Application No: FP/79/20/HH
Site Address: 31 Overdown Road Felpham PO22 7HW
Description of works: Loft conversion.

Thank you for your internet representation made on 29th June 2020 which has been recorded as an objection with the comments as follows:

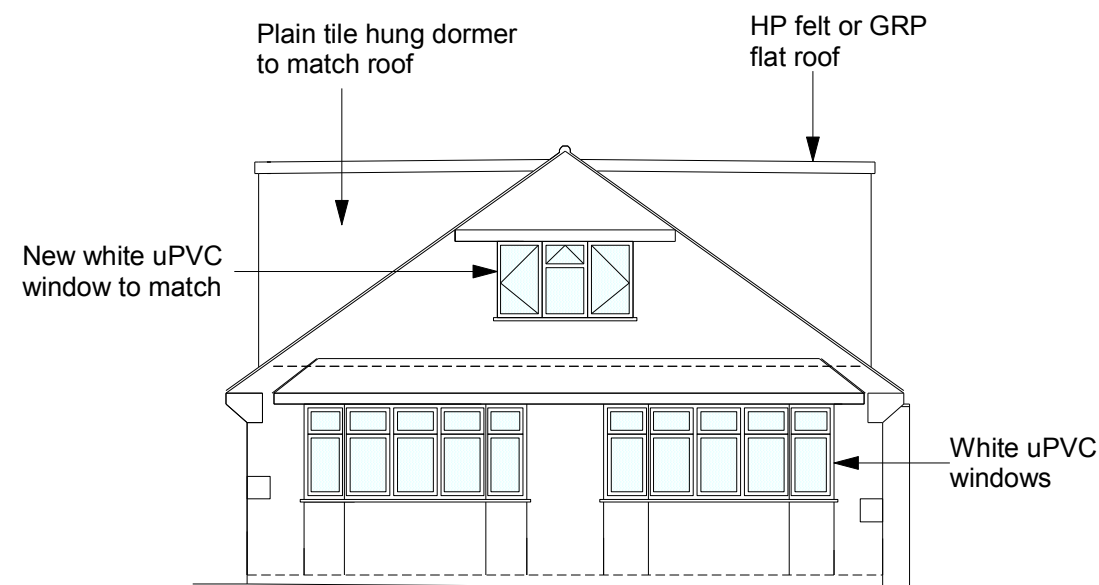
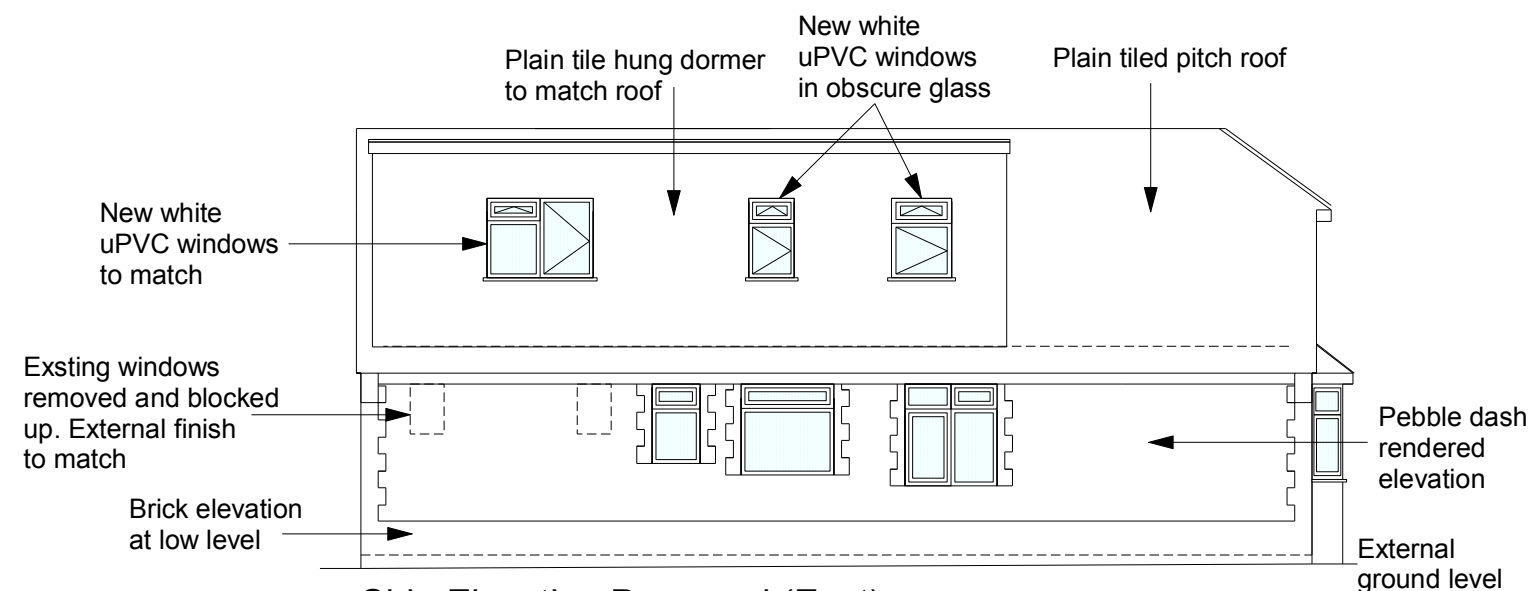
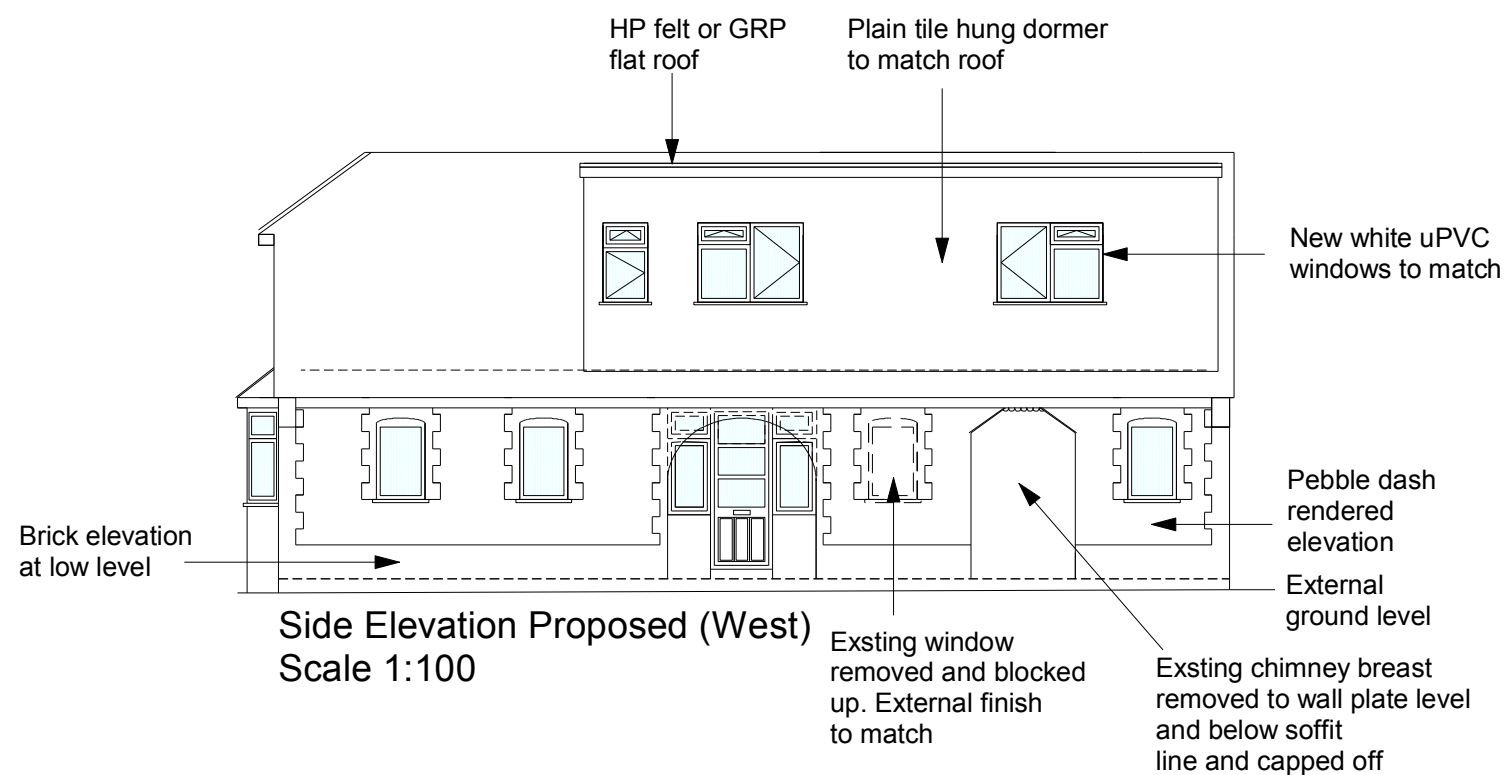
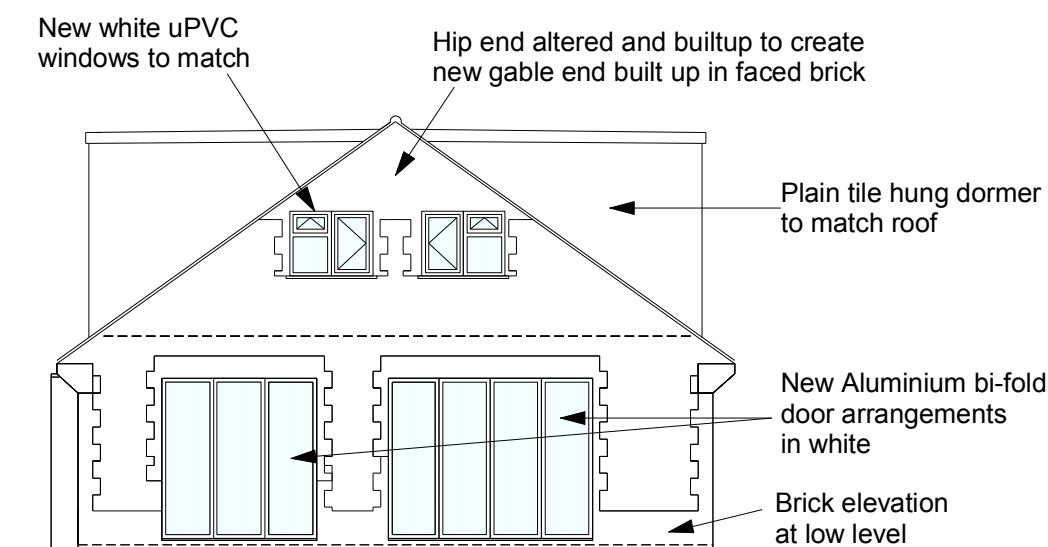
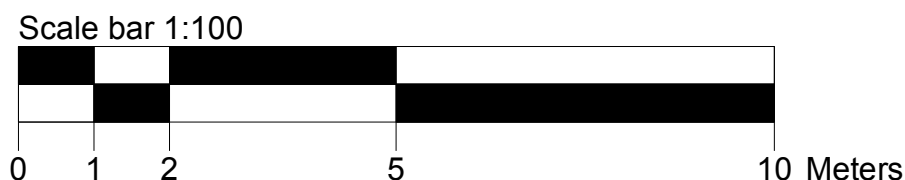
We have reviewed the drawings showing the proposed loft conversion, which is the first opportunity we have had to so. These drawings show two large flat roofed Dormers, one each side of the roof, running North/South along the roof. Each one will have side facing Dormer windows. We live next door, on the East side of No 31, Overdown Road, and therefore, we will be affected by the proposed Dormer on the East Side, shown on Architect's drawings PG003 & PG004.

The windows to the Bathroom and the En-suite will overlook the two West side windows of our lounge and the Conservatory. It is noted that obscured glass is specified for these windows, but they can be opened, as detailed. Also, the window to Bedroom 4, detailed with clear glass, will be positioned such that it will overlook both our Conservatory and the private part of our garden, at the rear of our house. This is where we have a Patio area, and so we will lose our current privacy. Also, we wish to highlight that we will be able to see into Bedroom 4, next door at No 31, from our first floor rear rooms, which is not satisfactory for either household.
